# NORTH LINCOLNSHIRE GREEN ENERGY PARK

1.1 Application Cover Letter

PINS reference: EN010116

Topic	Issue	Response for submission
Description of Development	ES Chapter 3 Project Description and Alternatives paragraph 3.2.3.8 states that the plastic recycling facility would have maximum dimensions of 132m x 90m with a maximum height of 25m. This differs from the dimensions of the process building in Table 1 (which are 130m x 80m with a maximum height of 28.9m; these accord with those in the draft Development Consent Order (dDCO)). This is further confused by the Explanatory Memorandum which states that the maximum scale of the building itself would be 100m x 50m.	Maximum dimensions have been made consistent across all documents. Where other possible dimensions are discussed the supporting text clarifies why, for example in the Explanatory Memorandum (Document Reference 2.2) there is explanatory text included to explain the scale of the maximum dimensions and give some other possible options which are being explored.

Title European Sites and SSSIs within 15 km of the Emissions Source

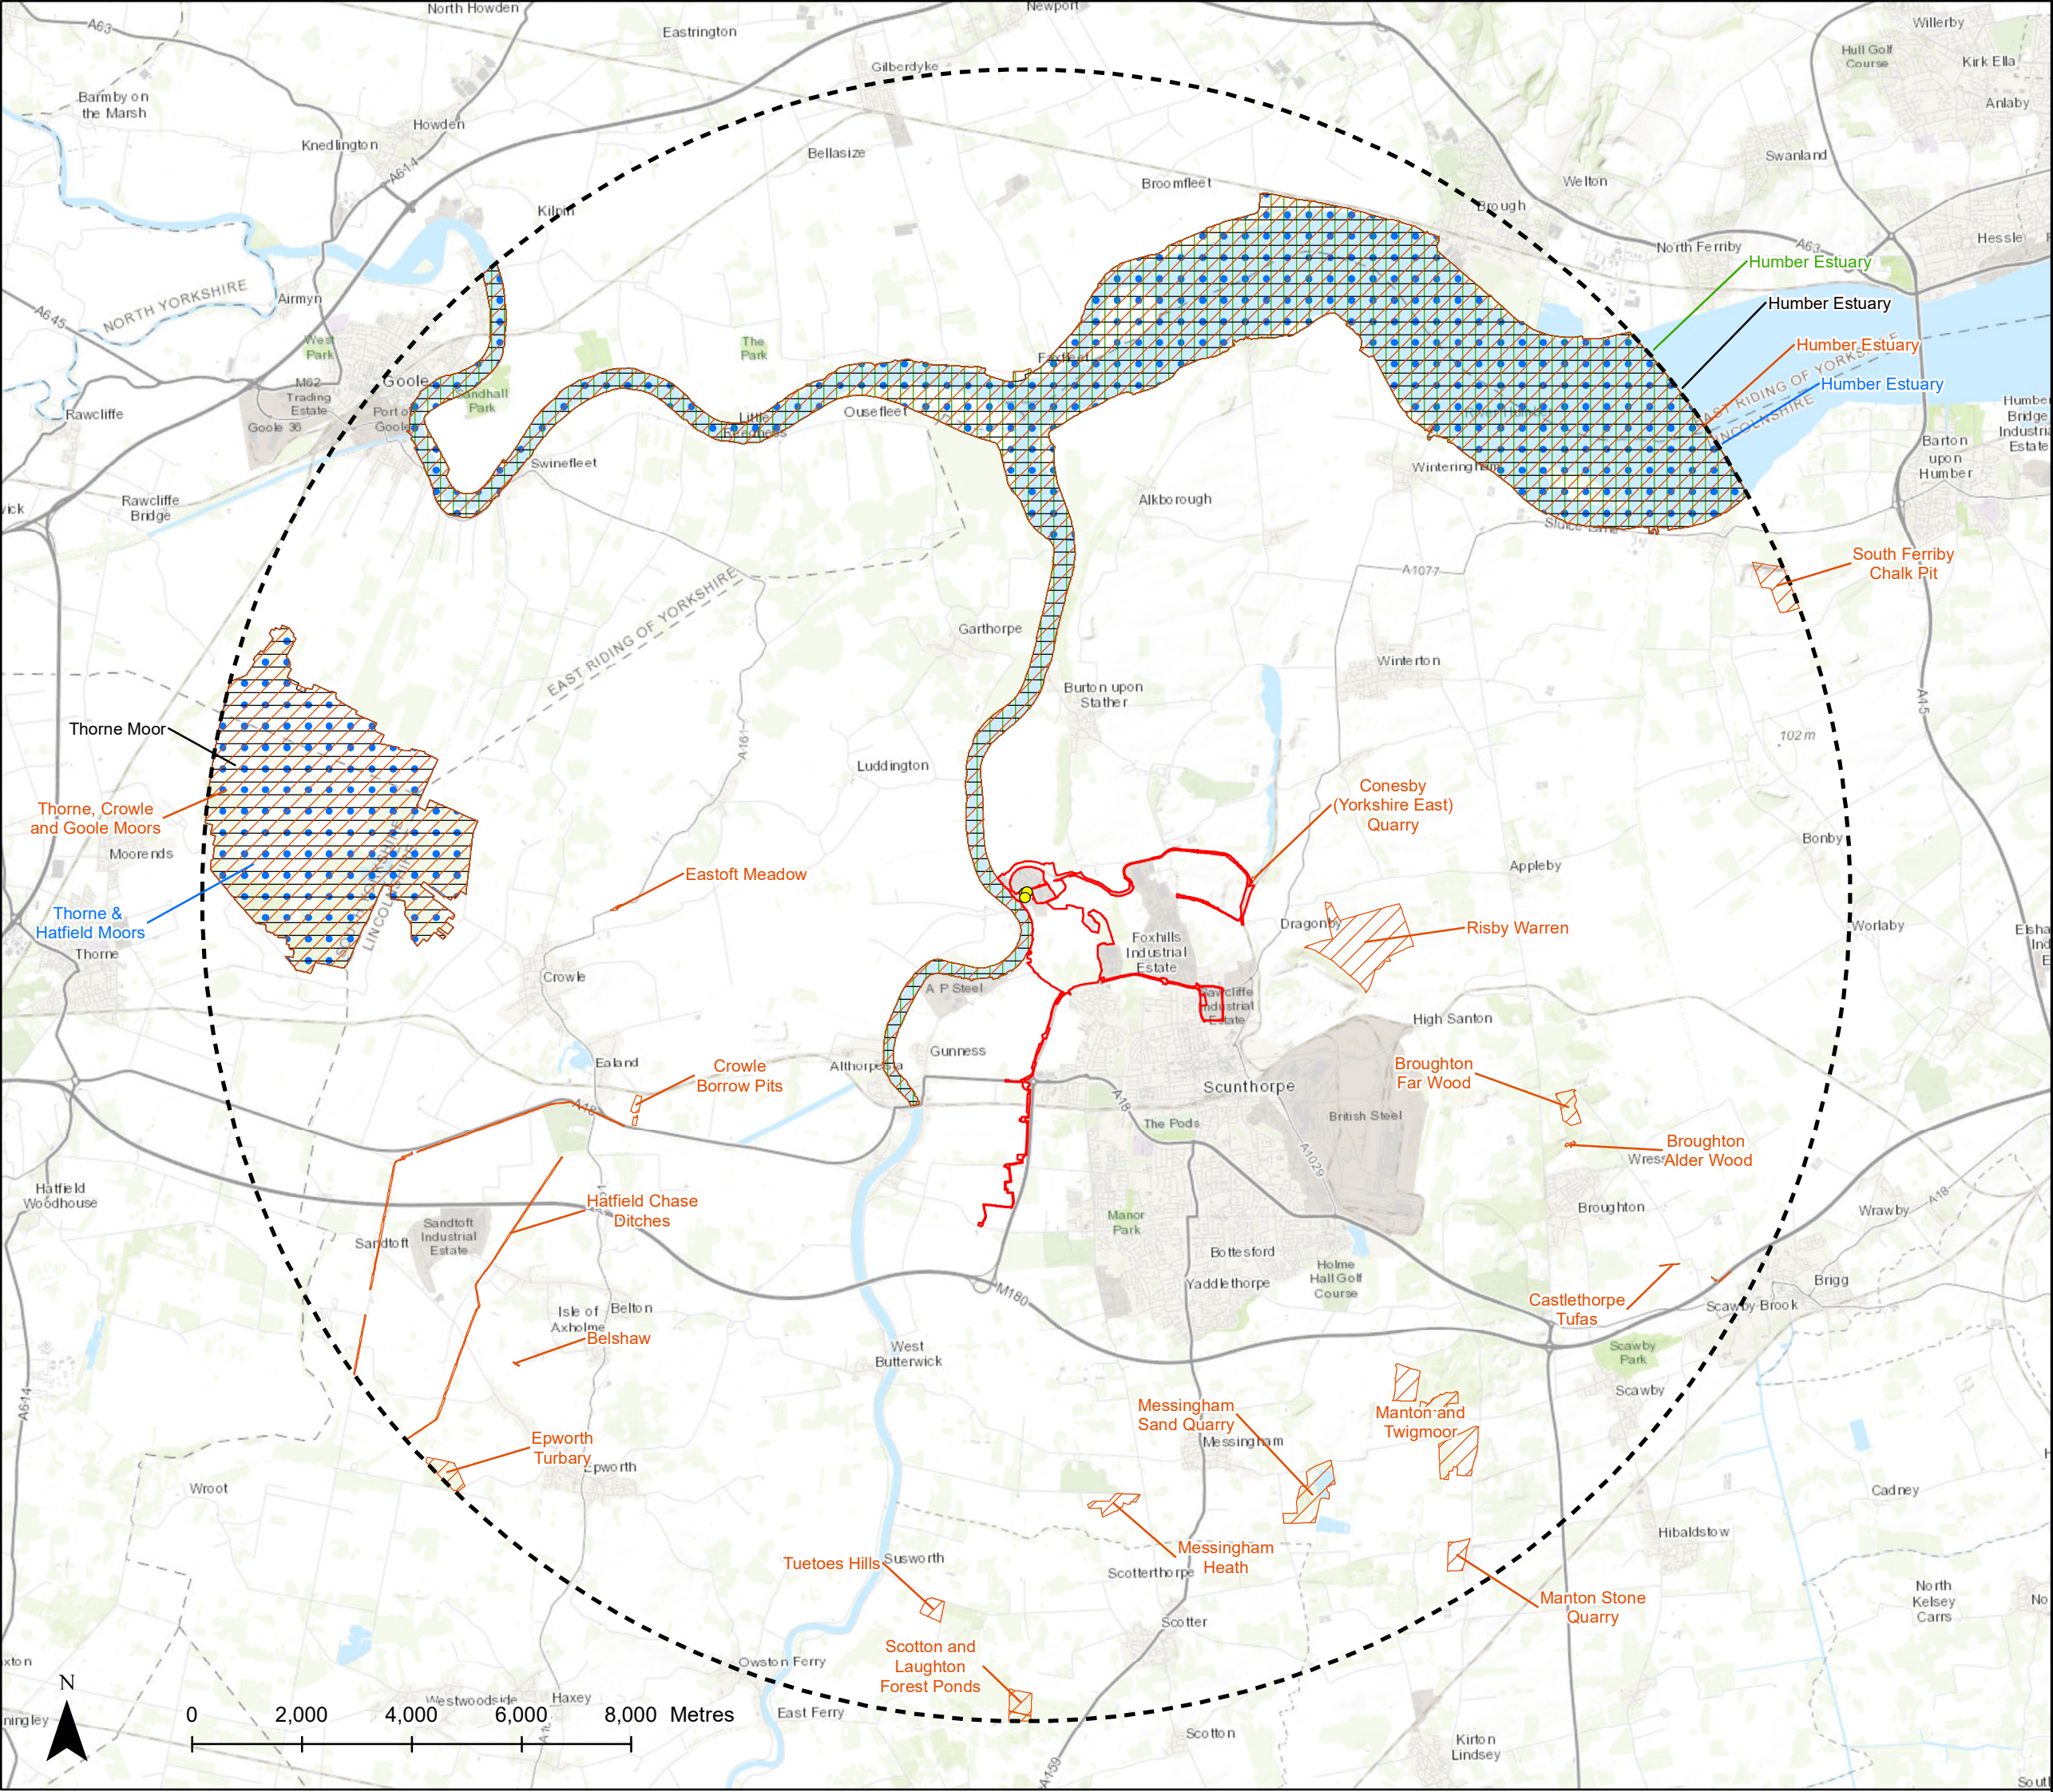
Plans of statutory or non statutory sites or features of nature conservation	Hatfield Moor Special Area of Conservation (SAC) is not shown on the plan illustrating European sites and SSSIs (Drawing Number NLGEP-ERM-XX-DR-Z-0013). The Report to Inform HRA states that this European site is located just outside the 15km study area and therefore was screened out of the assessment. However, ES Chapter 10 Ecology and Nature Conservation describes the site as being 12.4km from the Proposed Development. The Applicant is advised to clarify these discrepancies and to provide an assessment of any likely significant effects to the SAC if it is located within the 15km study area.	ES Chapter 10 (Document Reference 6.3.10) has been updated to clarify the distance of Hatfield Moor SAC from the Project.  Hatfield Moor SAC by virtue of its distance from the Project would only have required consideration in terms of potential effects from air quality impacts. Although the SAC is 12.4 km from the nearest part of the Order Limits it is in excess of 15 km from the ERF stack hence it not being included for consideration in the Report to Inform Habitats Regulations Assessment (Document Reference 5.9). The legends in the relevant Figure and Plans have been amended where necessary to clarify this matter.

Title Locally Important Ecology Designations within 2 km of the Order Limits

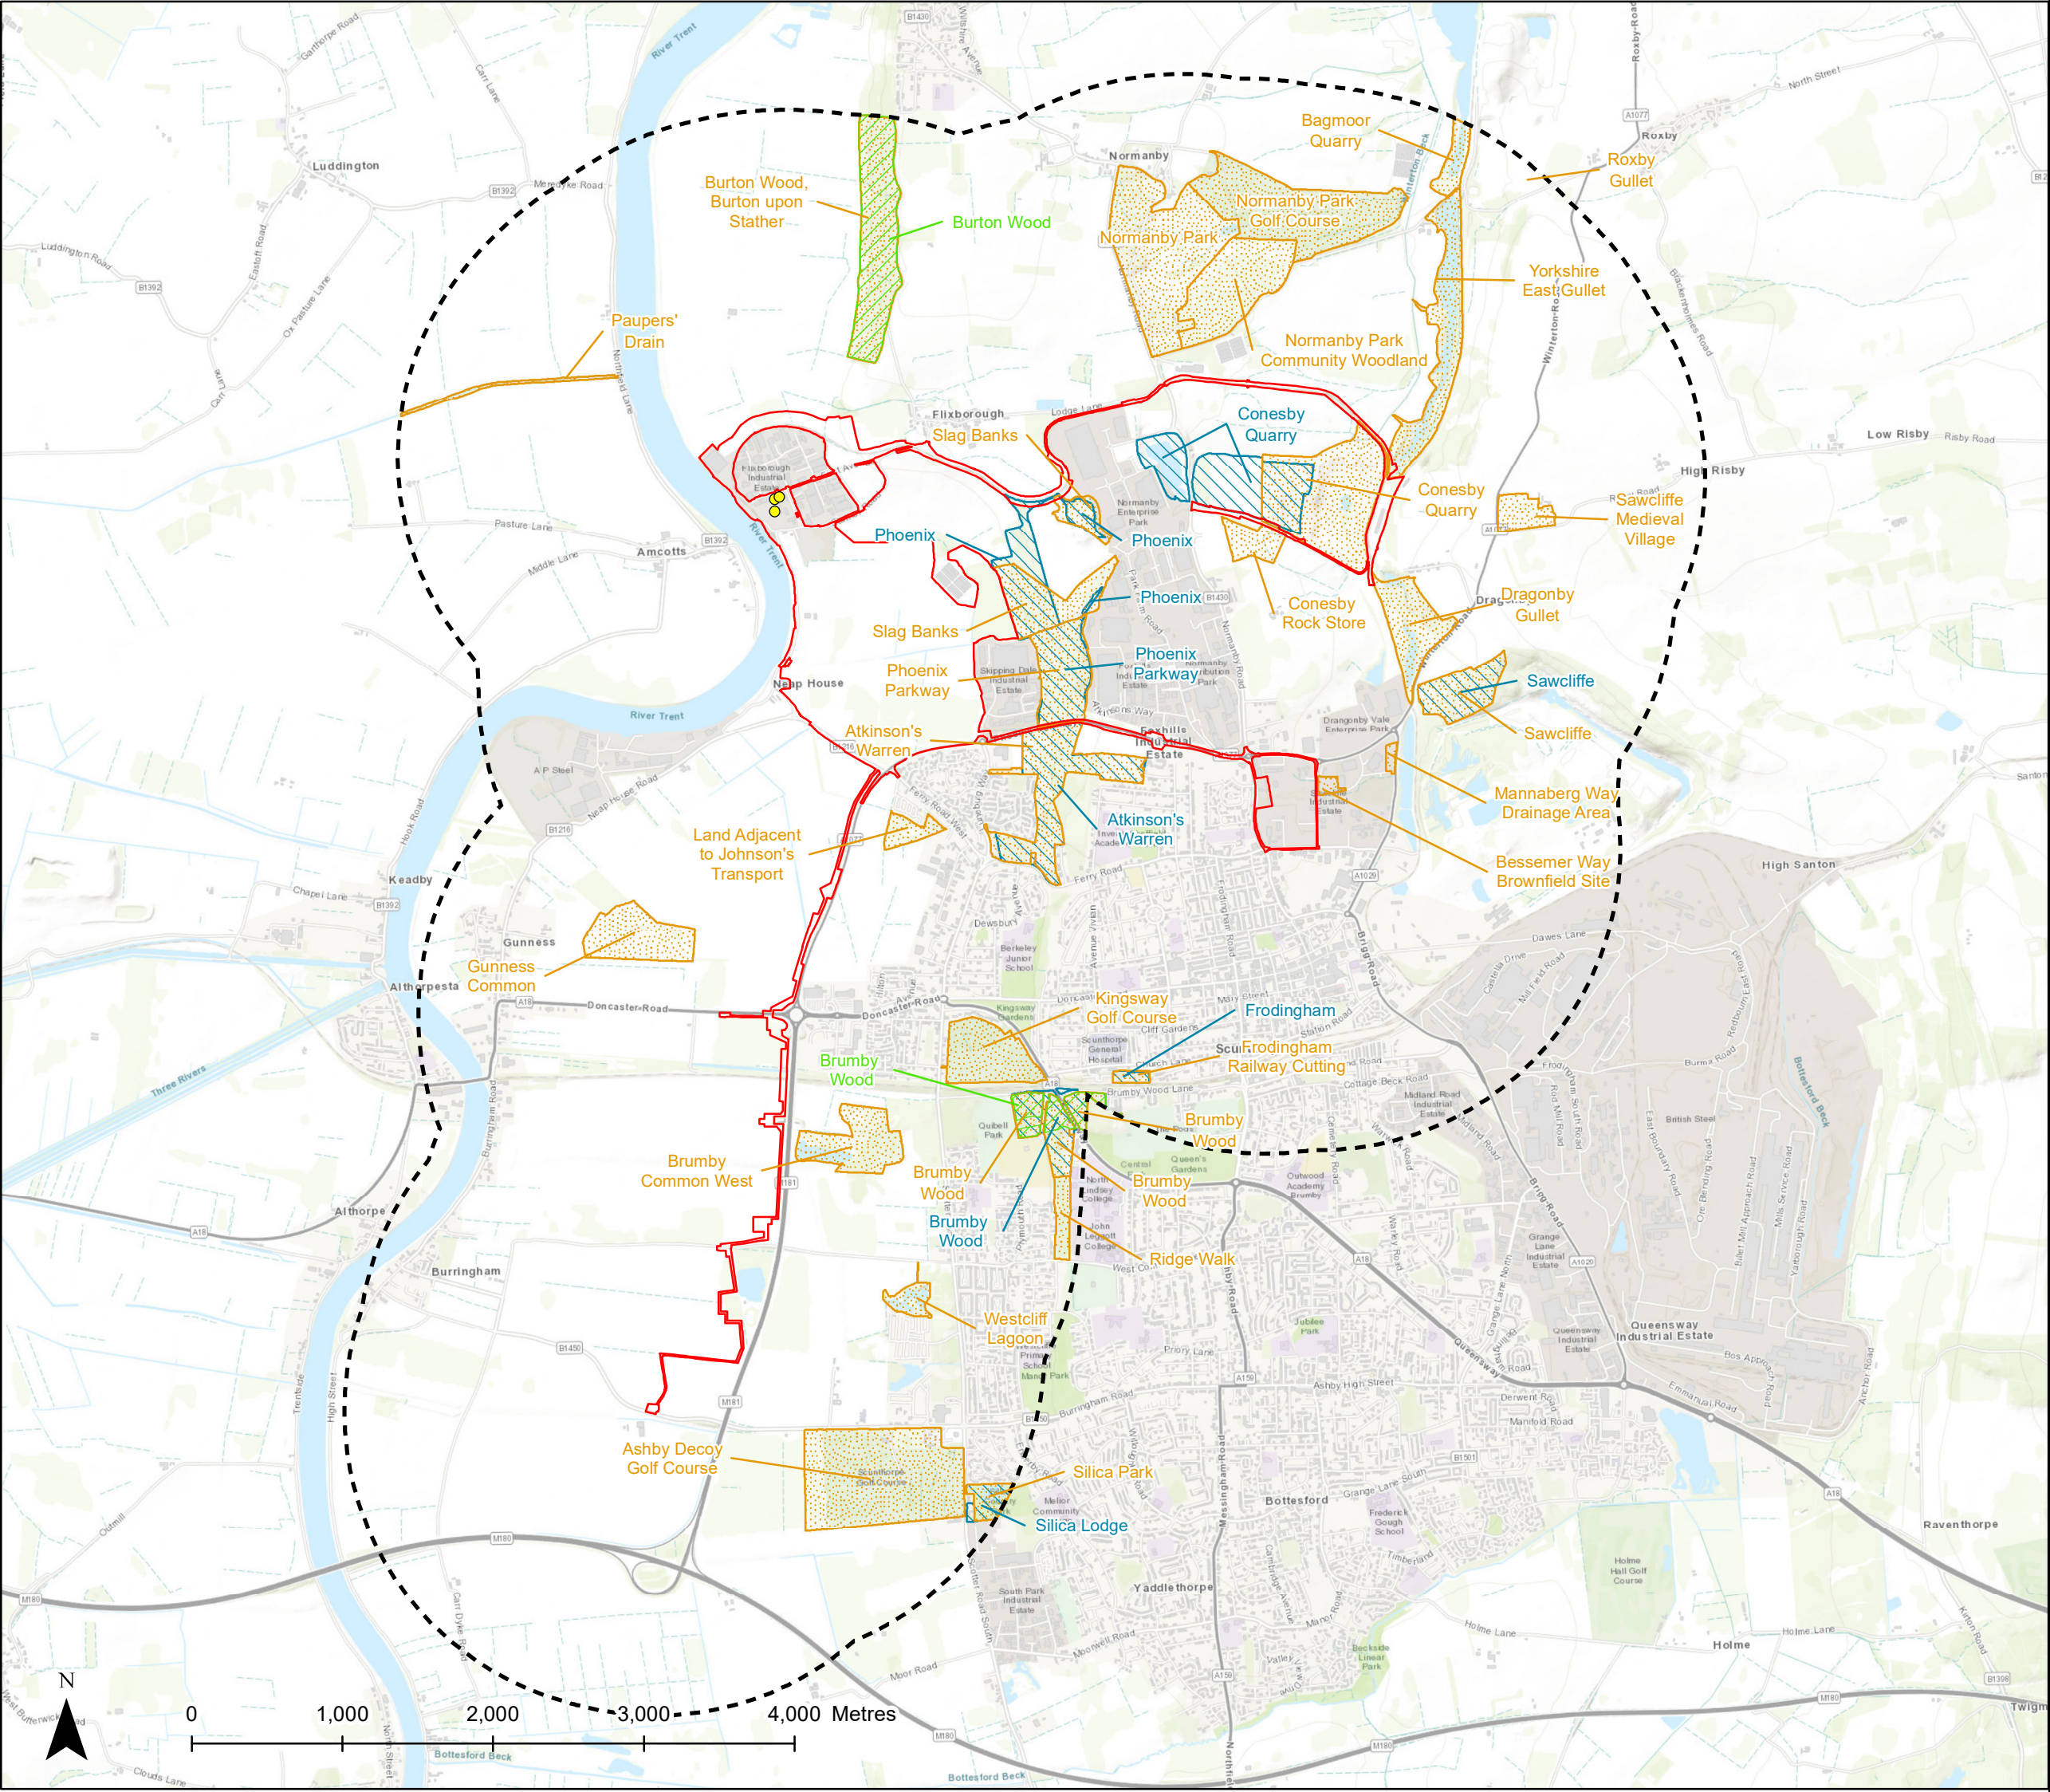
Plans of statutory or non statutory sites or features of nature conservation	A number of statutory and non-statutory designated sites of local ecological importance are not shown on the plan illustrating Locally Important Ecology Designations within 2km of the Emissions Source (Drawing Number NLGEP-ERM-XX-DR-Z-0016). The plan shows sites within 2km of the emissions' source (the stack) and does not extend across the full area covered by the application site eg sections relevant to the proposed district heat network and railway reinstatement are partially excluded. ES Chapter 10 Ecology and Nature Conservation and ES Chapter 18 Cumulative Effects identify additional statutory and non-statutory designated sites within a 2km area taken from the application site boundary (rather than the emissions source) that are not identified on Drawing Number NLGEP-ERM-XX-DR-Z-0016. The Applicant is advised to ensure that the plan supported in support of Regulation 5(L)(i) encompasses the full application site and accords with the ES.	The plans showing nature conservation sites (Document Reference 4.6) have been checked and updated as required. The updated versions of these Plans have also been fed into other relevant documents where necessary.
